**Our Case Number:** ABP-314724-22

**Re:** Railway (Metrolink - Estuary to Charlemont via Dublin Airport) Order [2022]  
Metrolink. Estuary through Swords, Dublin Airport, Ballymun, Glasnevin and City Centre to  
Charlemont, Co. Dublin

**'Railway (Metrolink–Estuary to Charlemont via Dublin Airport) Order 2022'**

***'Architecture Station Integration & Common Components Overview Presentation'***

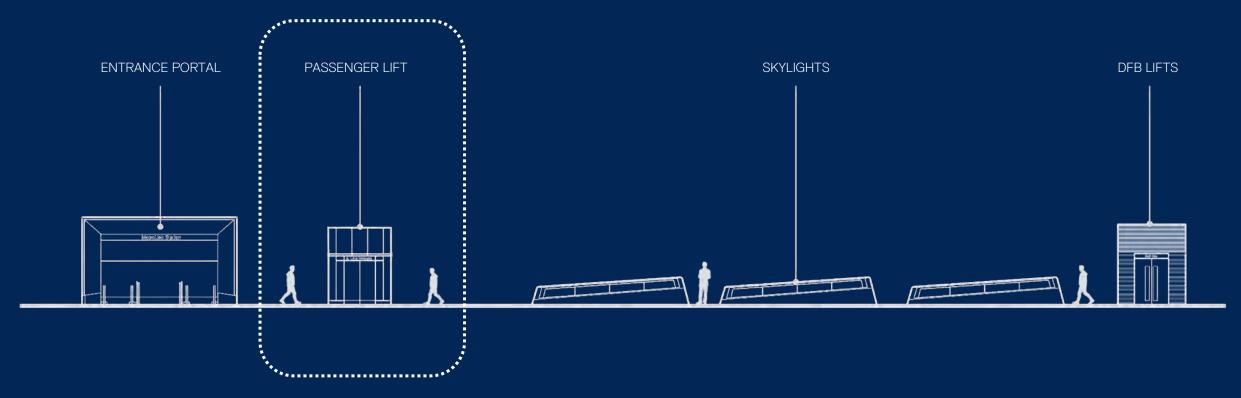
Possibility that station's interior finishes scheme may appear as only Grey on Grey, + Black with Blue/White lighting – and may look smart/ corporate, but may strike some as unwelcoming, particularly in underground stations, and if not maintained to a high standard.

Some additional White, and other colour interior finishes in stations may be of visual benefit e.g. plinth to walls and/or band of paving, of an Irish stone, individual to each underground station e.g. very broadly similar to TCD Geology building stone samples.

Consider from outset, potential need to incorporate security roller shutters or 'aircraft hanger' doors etc. into portal entrances.

Line-wide Identity & Branding

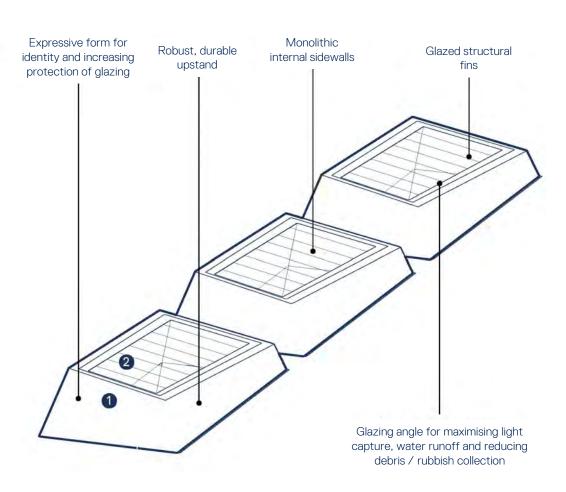
It may be helpful to add a simple 'M' in Metro Red, Silver or White colour metal etc. onto/ above/ straddling the parapet to front, and rear, of station portal entrances - for sight from a distance.

Replace hyphen between English - Irish translations of station names, with the Metrolink 'M' in a ring symbol.

Consider adding the 'M' symbols onto larger station's parapets, to side and front elevations.

Replace for portal side signage etc., the lower left, White ring around 'M' with Blue colour - to highlight as 'Blue Line' service, and when it is an interchange, the upper, Right ring into Green.
